## Appendix A – Liverpool Hospital Integrated Services Building (SSD 10389) - Response to Agency Submissions

### Agency Submissions and Response

PROJECT NO. 21807	DRAWING NO. A-SSDA-MW-16	ISSUE 08
STATUS SSDA AMENDMENT

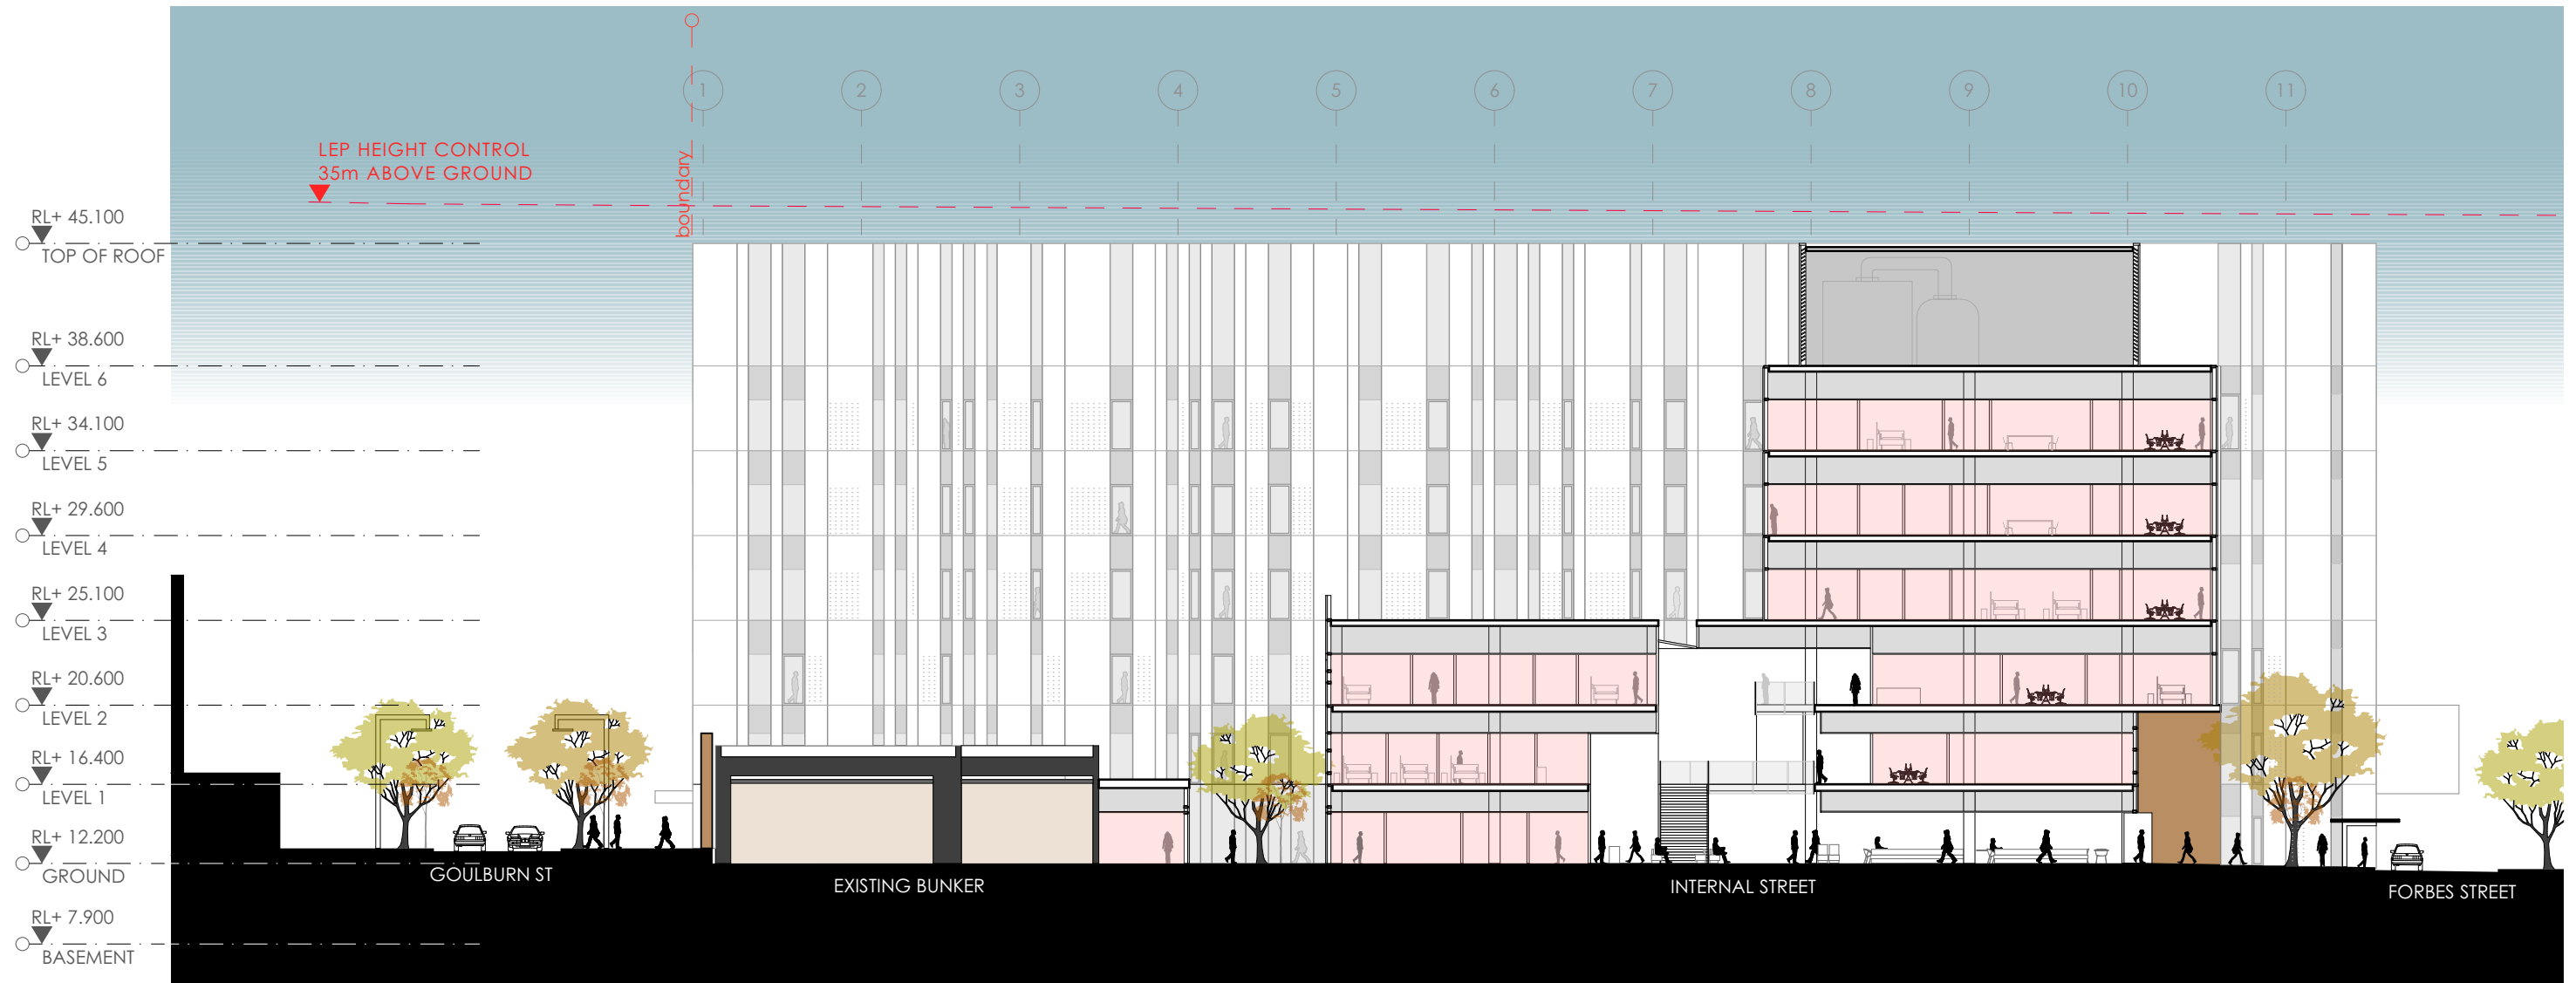
<p>no issues with Flight Path Report and no objections to the proposed Liverpool Hospital Redevelopment.</p>	
<p>CASA notes there could be a minor discrepancy in the documentation. According to Flight Path Report, the height of the 'LHAP Stage 2' is RL 43.1m. According to the architectural drawings ASSDA- MW-16/18 of 8 May 2020 and the Environmental Impact Statement, the maximum 'Top of Roof' of the north/south In-patient Unit tower is 45.1m.</p>	<p>The Aviation Flight Path Report prepared by Avipro and included at <b>Appendix M</b> has been amended to reflect the height of the LHAP Stage 2. AviPro confirm that while the Stage 2 structure will be above the height of the Primary HLS by 2.39m, this is not significant as the preferred flight path does not cross over the Stage 2 building and therefore will not impose a constraint on the HLS. Further discussion is provided at <b>Appendix M</b>.</p>

Figure 1: Historical drains and buildings and footprint of Higginbotham (1995) excavation boundary.

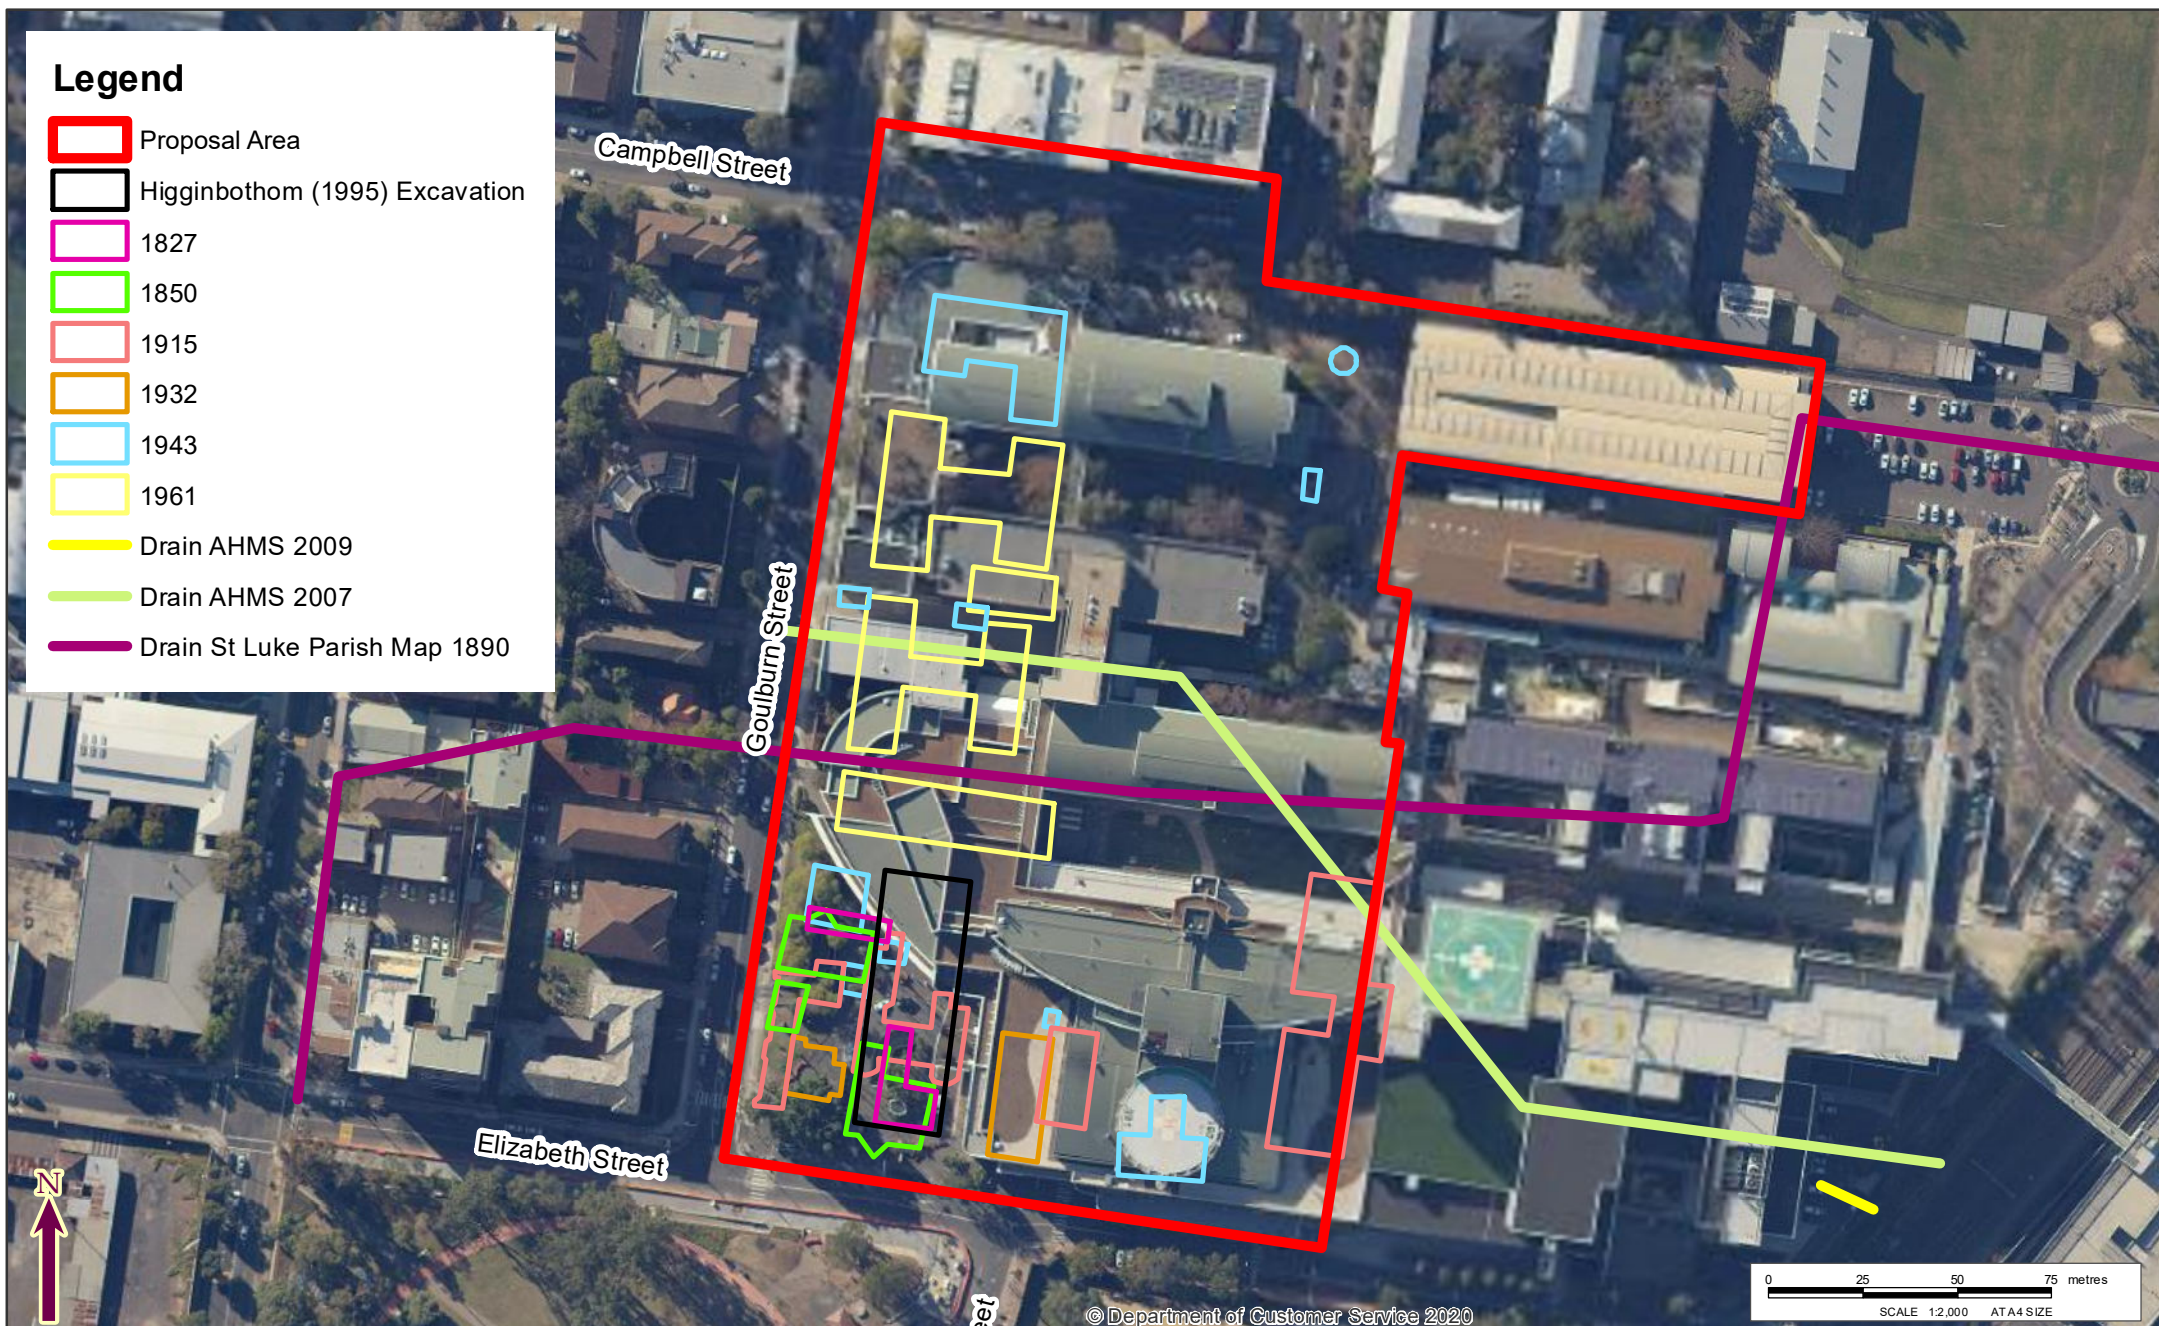
<p><b>Heritage NSW</b></p>	
<p>The following comments have been made on the archaeological heritage content of the Statement of Heritage Impact (RPS 2002).</p> <p>The report references archaeological investigations undertaken in 1993 (Higginbotham) and 2009 (AHMS) that both uncovered historical phases of site occupation, with remains such as footings associated with the 1820s Moore Hall, a box drain, a ditch, postholes, deposits and post-1865 artefacts. Heritage NSW observes that both investigations were sampling programs involving test trenches, rather than larger-scale open area excavations, which is of note given the scope of archaeological evidence encountered during the works. Taking this evidence into consideration, the report assesses the archaeological potential of the site as low to moderate in Section 5.1 and low to nil in Sections 7.2.6 and 8.1, with high potential for historical drain/s to survive intact in localised, less disturbed areas of the site without basements. It is noted in the report that the sandstone capped box drain uncovered in the 2009 excavations is not depicted on Liverpool town plans. However, it is not made clear why other un/anticipated archaeological evidence may not survive <i>in situ</i>, as well as the drain/s, within less disturbed site areas.</p> <p>Heritage NSW does not concur with the assessment of archaeological potential and observations of impact. It is reasoned that a diverse archaeological resource, dating to various historical phases and including unanticipated remains, has previously been discovered on site. Further, as mentioned in the report, it is noted that areas without basements on the site may be (reasonably) undisturbed and, it is argued, may therefore contain a range of archaeological evidence.</p>	<p>RPS have provided further detail on the Moore Hall and AHMS 2007-2009 assessment. This is included at <b>Appendix I</b>.</p> <p>Additional assessment of the archaeological potential on the site has also been undertaken. The updated information supports the conclusions of the archaeological potential presented in <i>The Liverpool Health and Academic Precinct – Integrated Services Building and Refurbishment of the Clinical Services Building: Statement of Heritage Impact</i> (RPS, 2020).</p> <p>The additional assessment also confirms that the proposal area has a low and low to nil potential of containing archaeological remains associated with the structures identified in the 1827, 1850, 1915, 1932, 1943 and 1961 plans and aials. The exception to this is the potential for drains, which is based on the 2007 archaeological monitoring program and it is noted that there is moderate to high potential for similar drains to survive in localised, less disturbed areas of the proposal area. Therefore, the assessment of the archaeological potential presents in the Statement of Heritage Impact will not be altered and the conclusions drawn broadly correspond.</p> <p>An unexpected finds protocol has been prepared in the event archaeological remains not anticipated are identified. Further discussion is provided at <b>Appendix I</b>.</p>

<p>The significance assessment presented in the report (Section 6.6) only addresses potential 19th century drains on site, which are assessed as of Local significance for their association with the early town of Liverpool. In Sections 7.2.6 and 8.1, drains are considered to have the potential to be of Local or State significance, dependent upon the evidence and intactness. The significance assessment therefore appears unresolved. A significance assessment for the historical archaeological resource of the entire site (as a whole) has not been included.</p>	<p>The addendum prepared by RPS confirms that the significance of the drains networks identified is likely to be significant at a local level only (as stated in Section 6.6.1.1 of the Statement of Heritage Impact submitted with the EIS). It is noted that the previous archaeological assessment found that the archaeological remains including any potential drain network would be significant at a local level only.</p> <p>Further to this, RPS have provided an additional assessment of significance for the potential historical archaeological remains of the proposal area in accordance with the 'Assessing Significance for Historical Archaeological Sites and Relics' OEH 2009 criteria. As noted in the</p>
